Our ref: STH11/00053/08
Contact: Emma-Rose Cooper 02 4221 2548
Your ref: SSD-10422

SEARS APPLICATION SSD-10422 - 416 AND 524 BERRIMA ROAD MOSS VALE, NEW BERRIMA BRICKWORKS

Emma-Rose Cooper
Development Assessment Officer
Community and Place | South Region

SCHEDULE OF AREAS

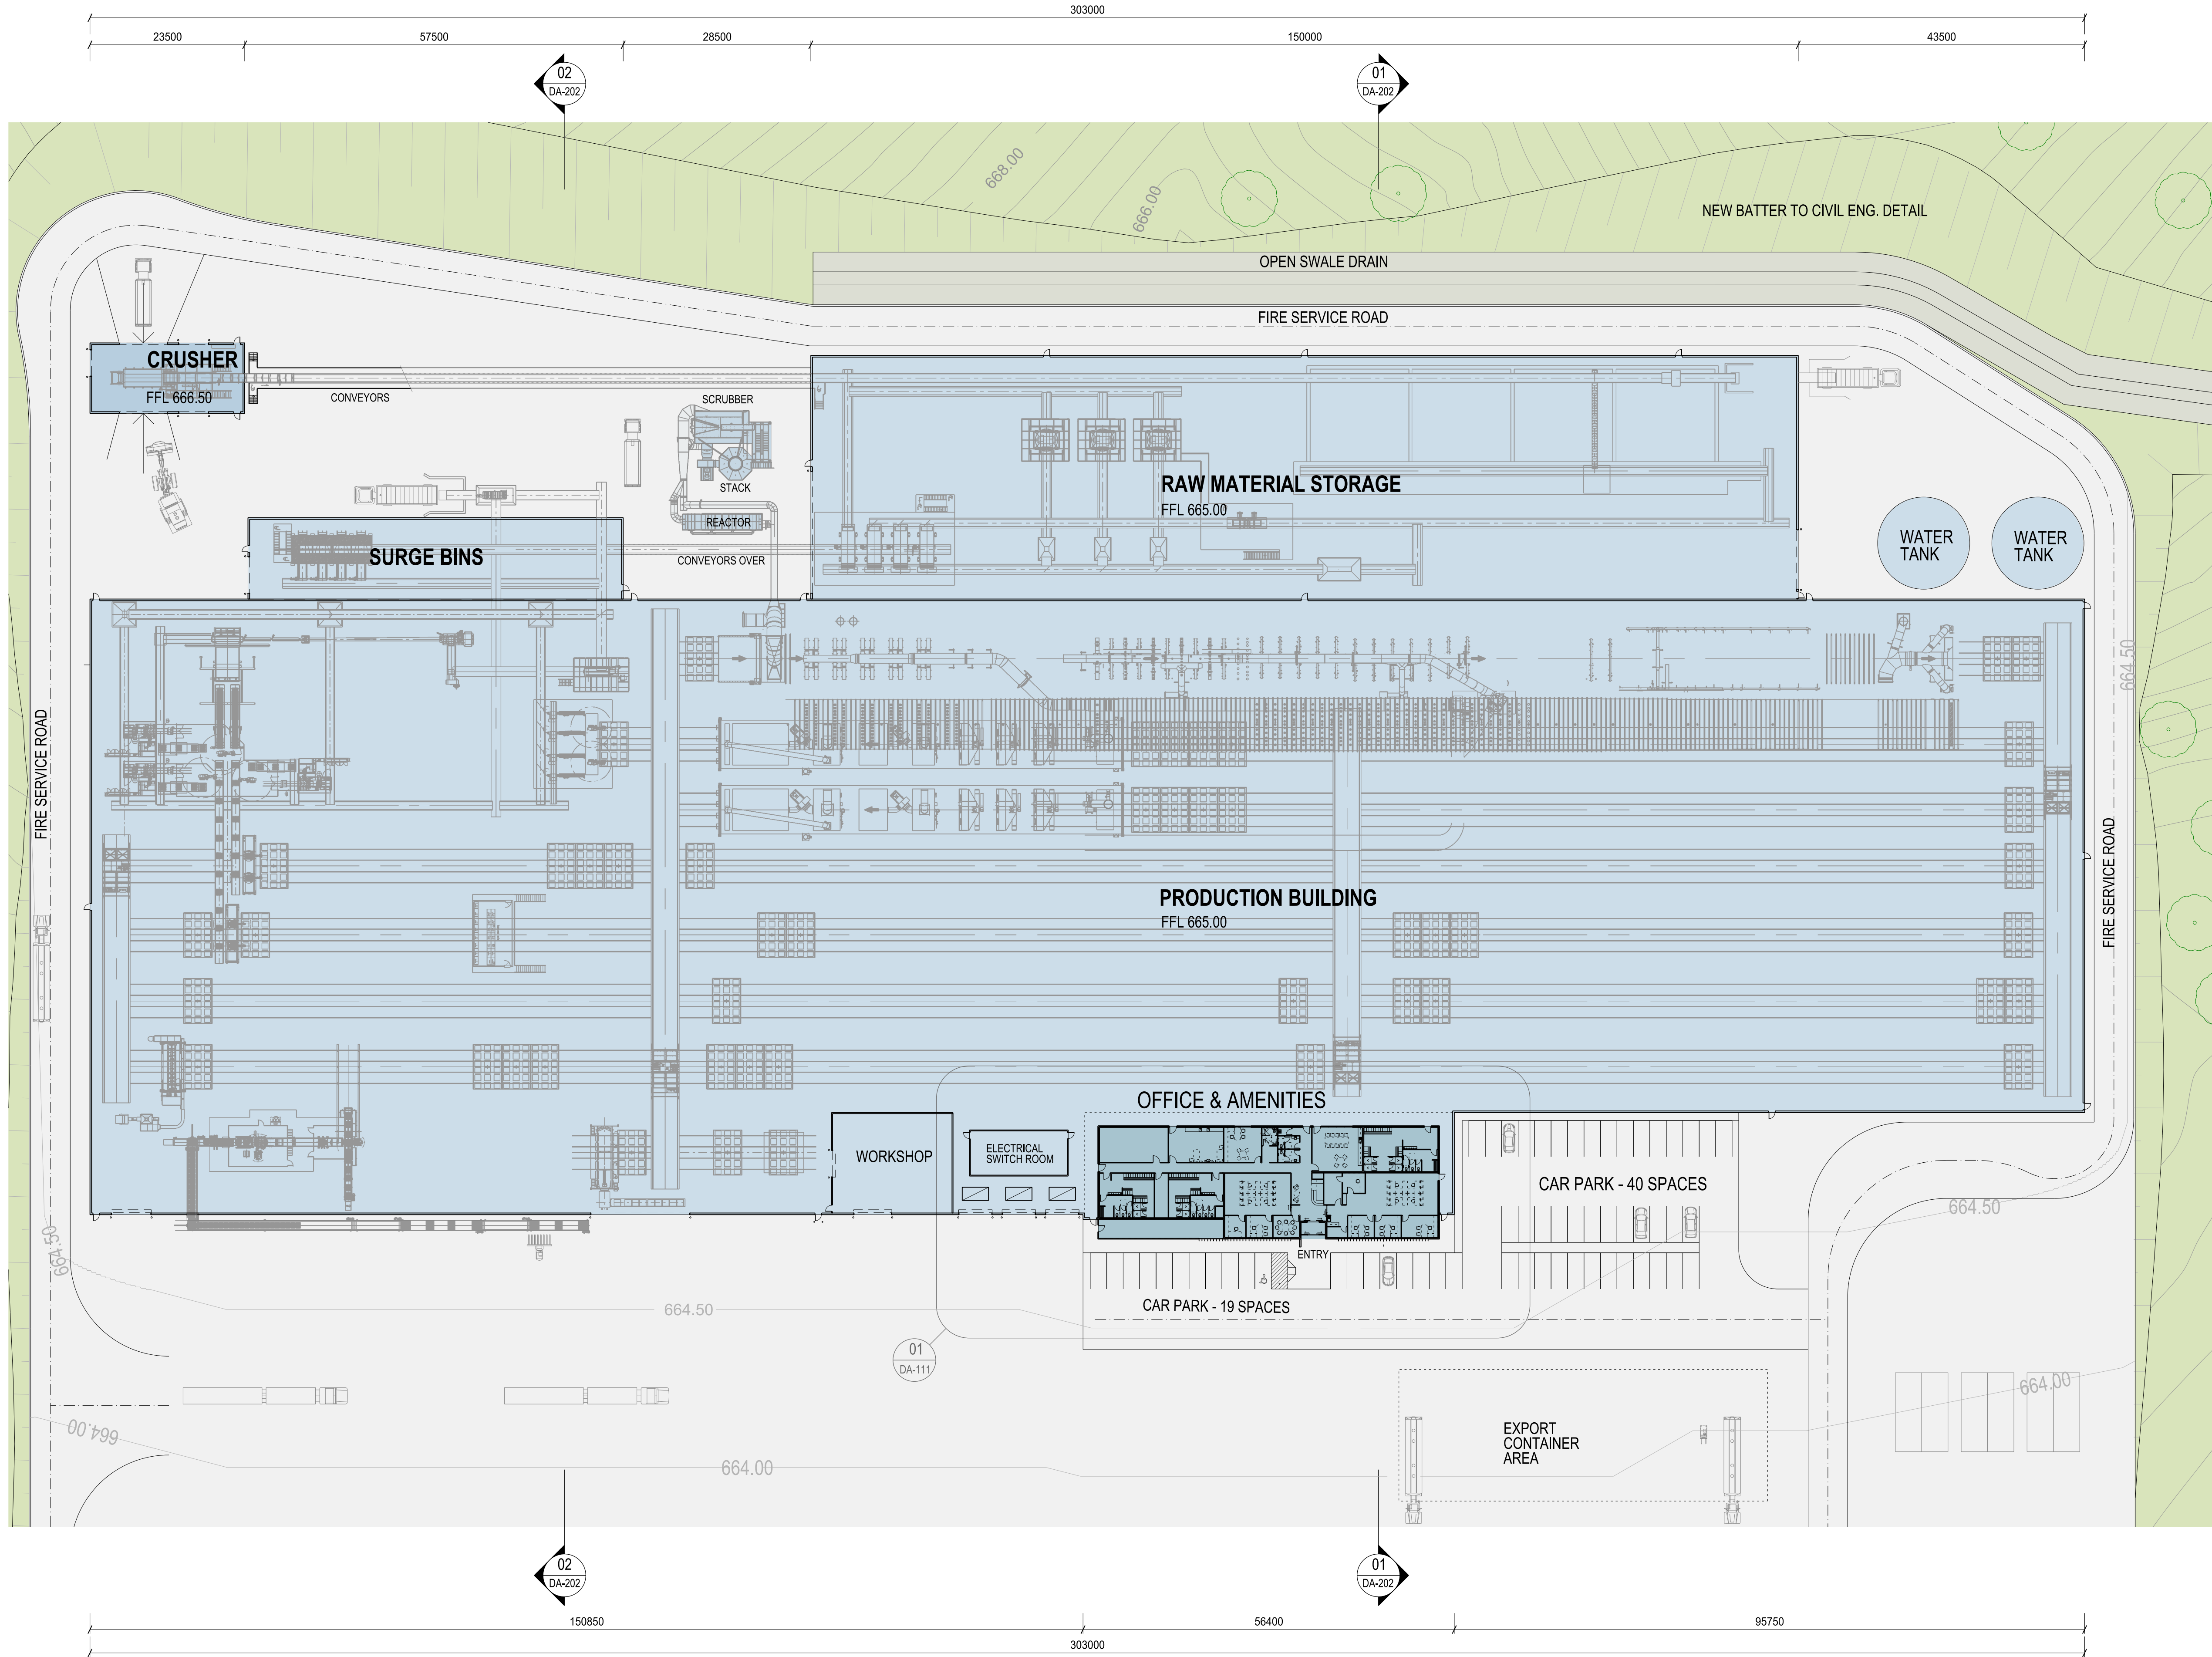
2. The submitted EIS mentions opportunities for material exportations, however it is unclear if this relates to the export container area identified on the submitted site plan. TfNSW seeks clarification on how the export container area will operate and the traffic volume associated with it.
